Recommendation Report for Planning Permission for Works or Extension to a Dwelling

REF NO: A/105/22/HH

LOCATION: 14 Merryfield Crescent
Angmering
BN16 4DA

PROPOSAL: Single Storey Front infill Extension.

PROPOSED GROUND FLOOR PLAN

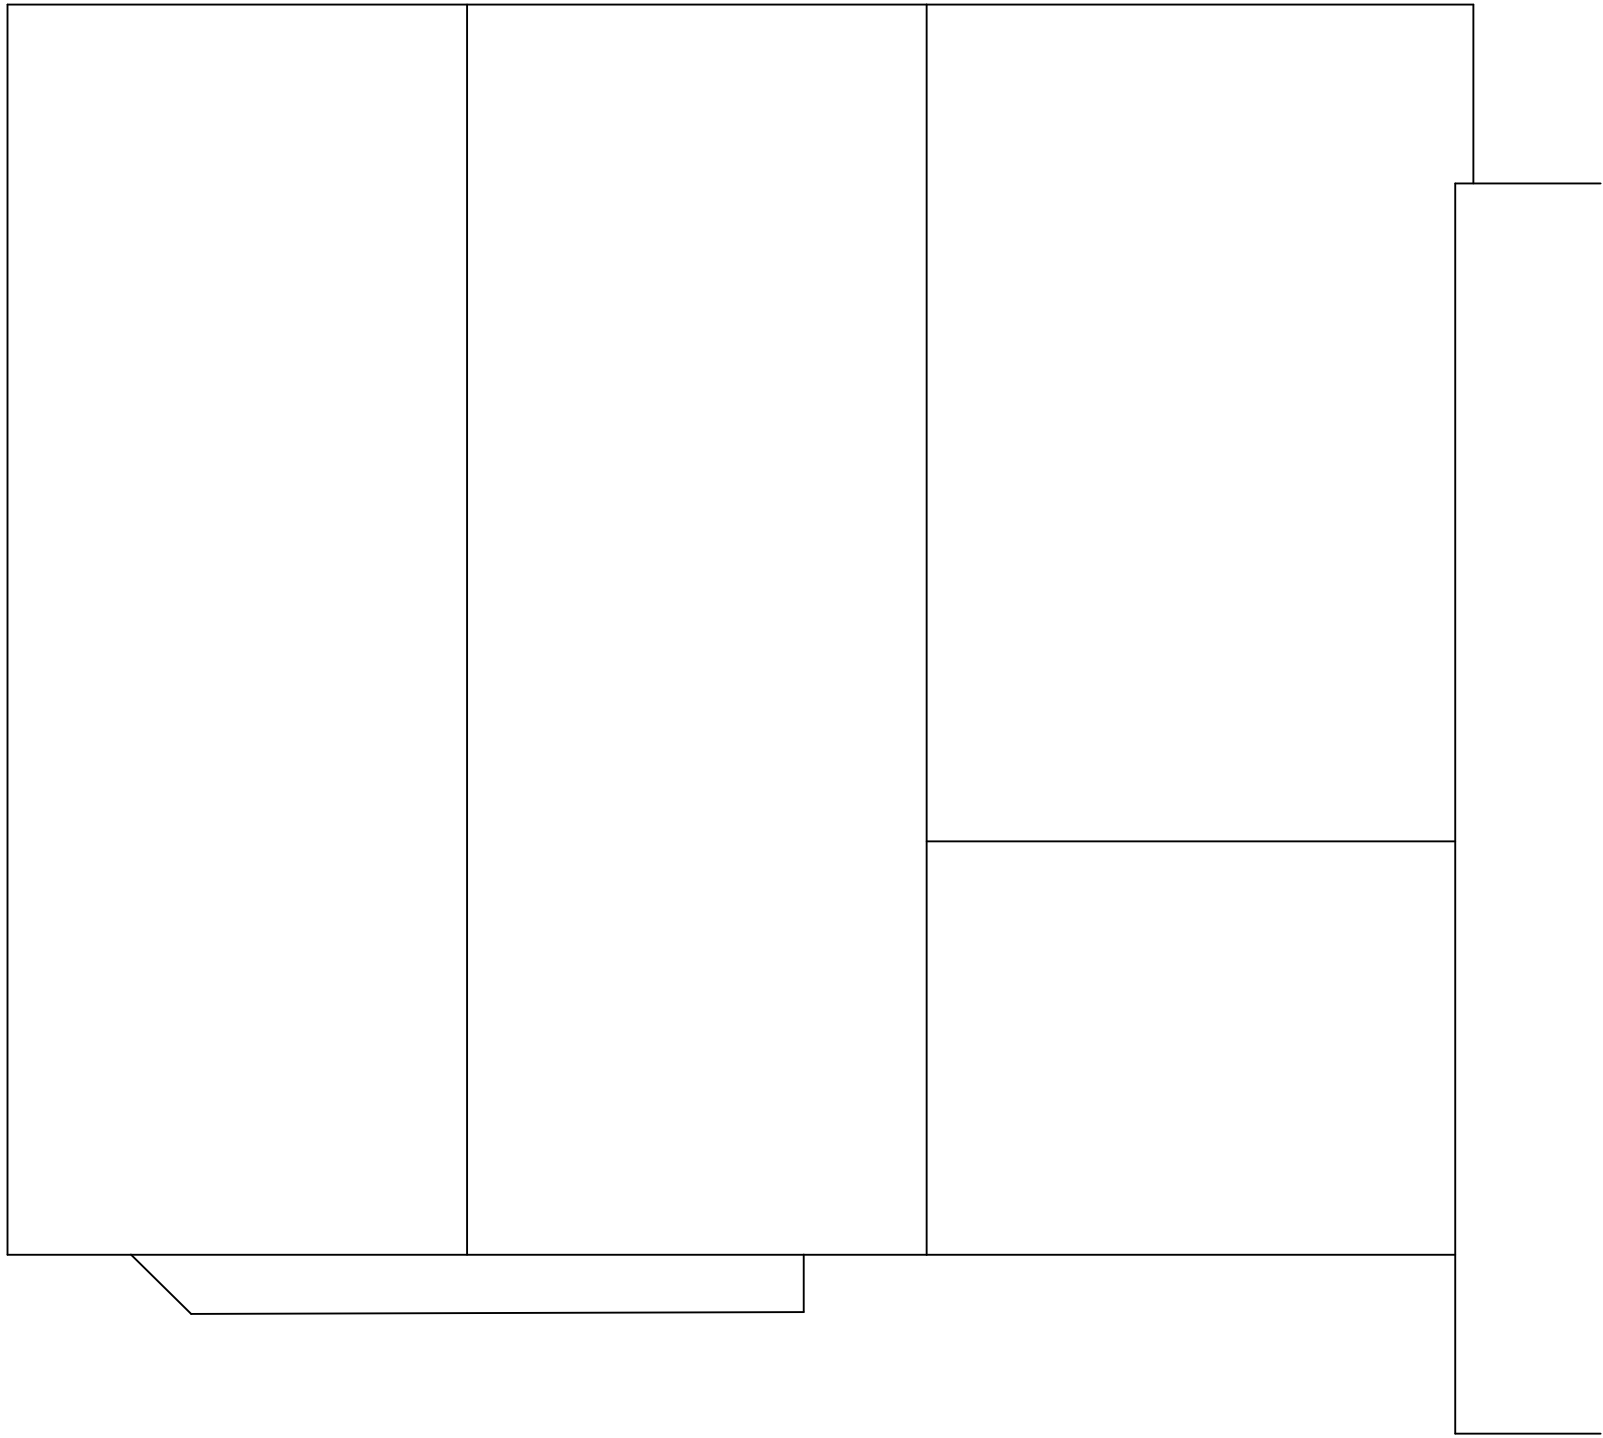
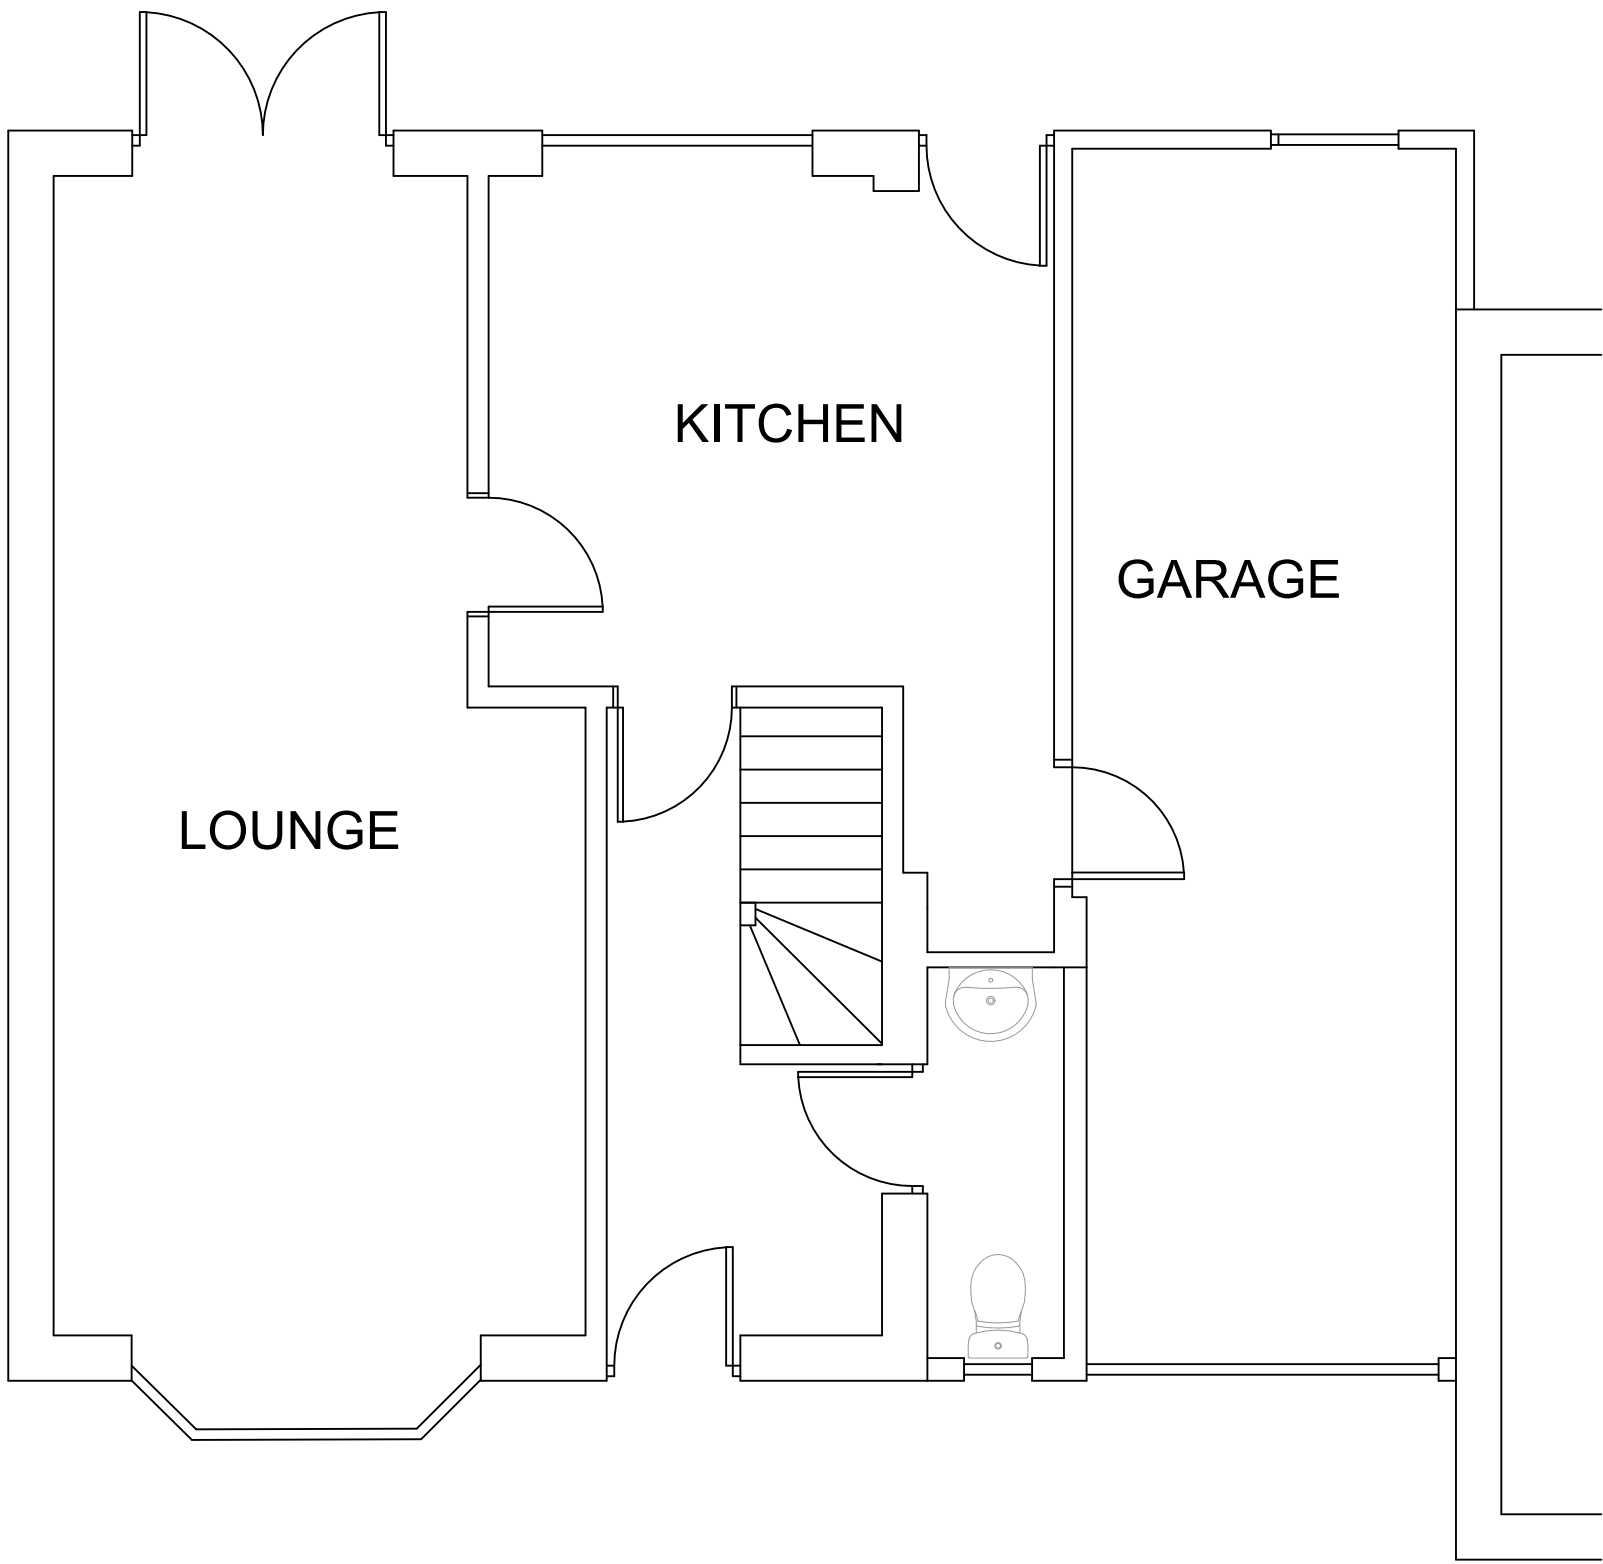
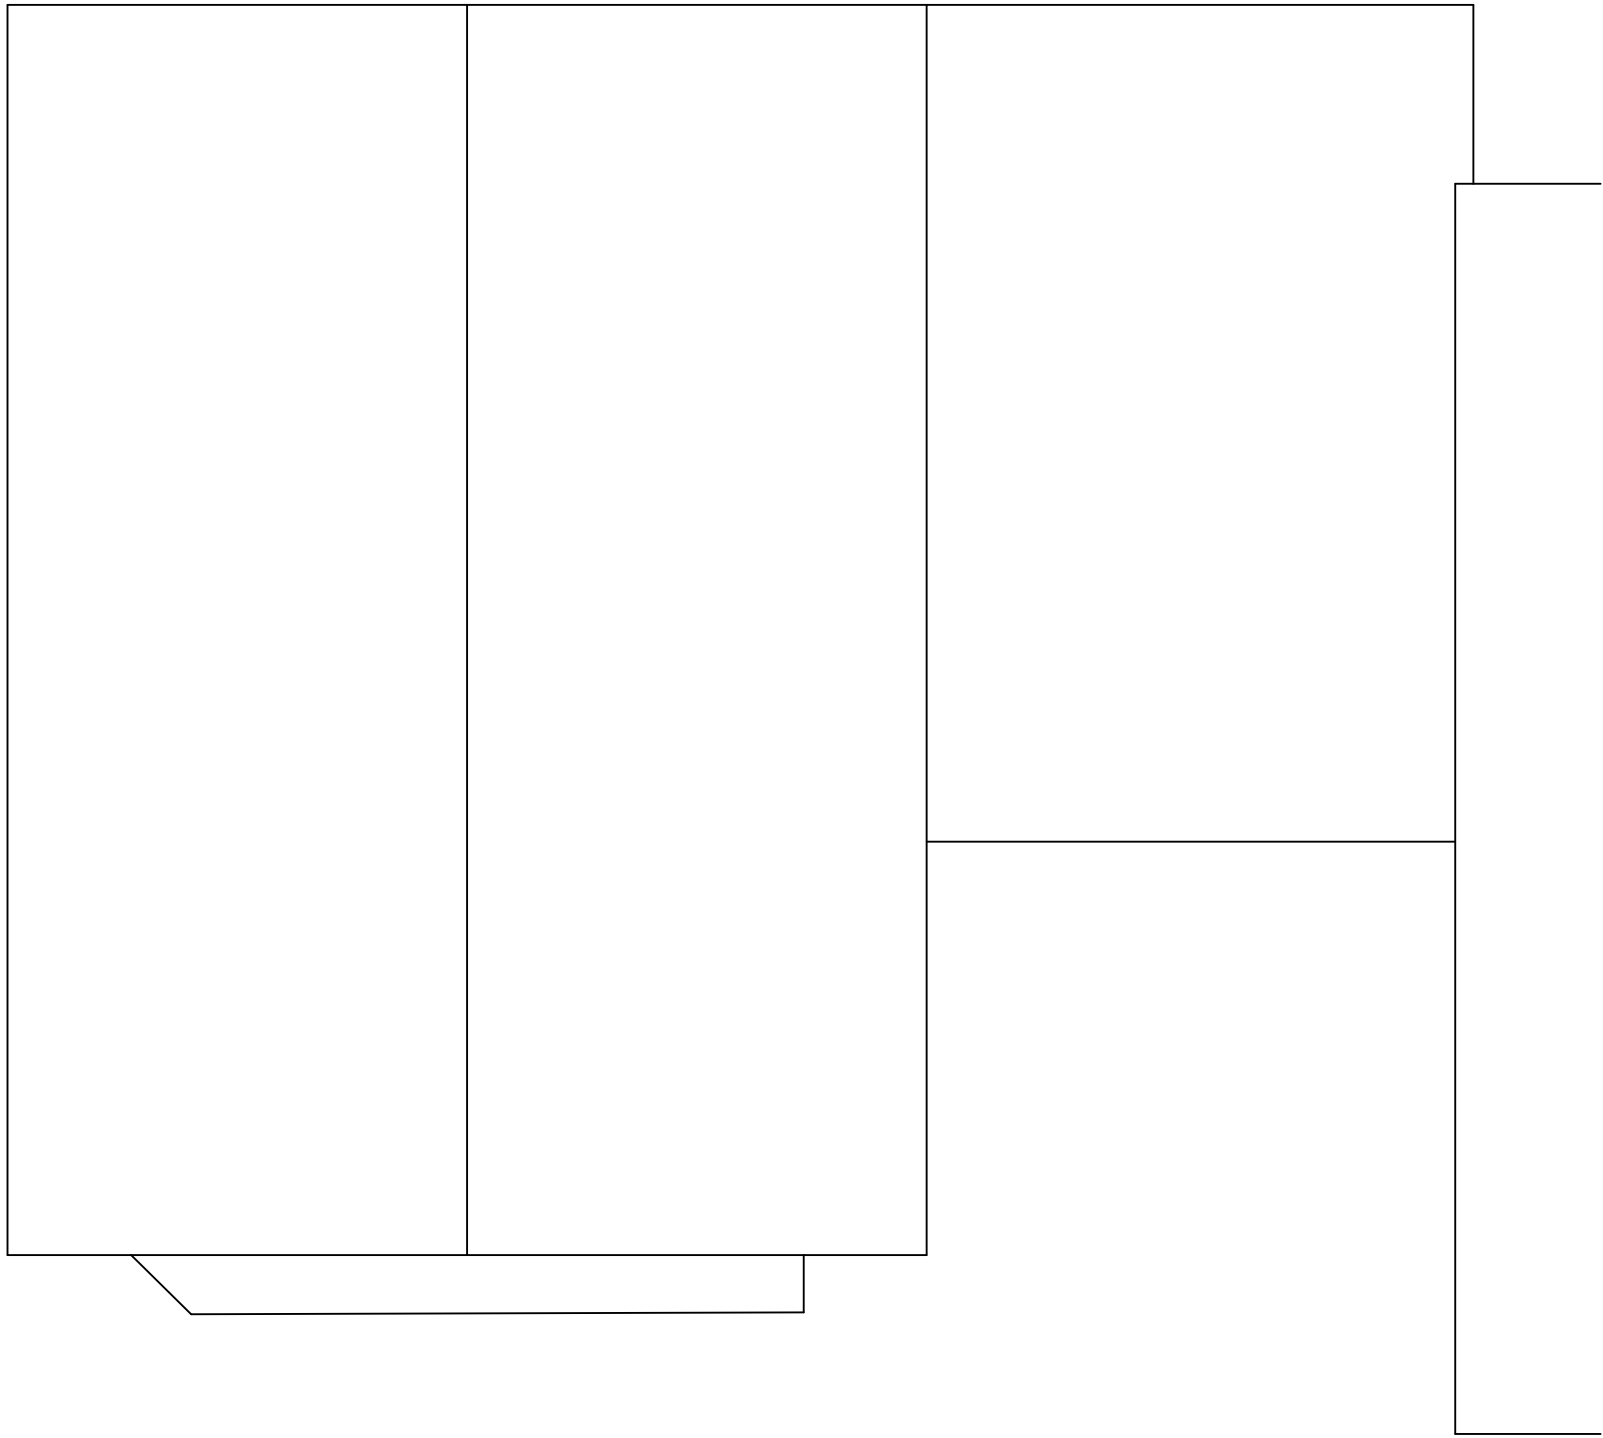
The extension is approx. 2.7m in depth, 3.5m in width, and reach a peak height of approx. 3.7m with eaves at 2.4m. There is to be a pitched roof design which would rise to meet the underside of the first floor front window made interlocking tiles. The scale of the proposed extension is minor, remaining visually subservient to the host dwelling. There is to be cement board cladding introduced to the front elevation of the extension. Cladding is not dominant but not an uncommon feature within the area and is similar to the commonly seen shiplap boarding. However, to ensure the colorations and finishes reflect local vernacular, a condition is recommended requiring a submission of these details.

The scale and siting of the proposal are such that it would project up to the existing front elevation of the property, not exceeding the forward most building line in accordance with Section M of the Arun Design Guide. The terrace in which the dwelling is situated, consists of 7 No. dwellings of similar design, five of which feature recessed attached garages. In constructing this extension, the recessed garage form would be lost and as such, this semi-regular design within the terrace would be hindered. However, the extension would remain at single storey and would not result in a complete loss of the staggered form design and so would preserve the single storey design. Additionally, the street features a variety of differing housing designs and there is an example of a similar extension a short distance North on a connecting road (Beech View). Although the proposal would result in a visual alteration to the street scene, it is not a significantly adverse alteration and is not grounds for refusal.

The siting and scale of the proposal is such that it would not intersect any 45-degree sightlines or light accessibility lines as illustrated by Section M of the Arun Design Guide. Furthermore, there will be no new viewpoints. There will be no adverse impacts by way of overbearing, overshadowing, or overlooking.

The extended garage will be connected to the wall of the adjoining property No. 12 Merryfield Crescent thereby minimising any adverse residential amenity impact on the adjoining property. However, the connecting space is an extension of the existing garage and is not habitable space.

- 3 No development above damp proof course (DPC) level shall take place unless and until a schedule of materials and finishes to be used for external walls (and roofs) of the proposed extension have been submitted to and approved by the Local Planning Authority and the materials so approved shall be used in the construction of the extension.
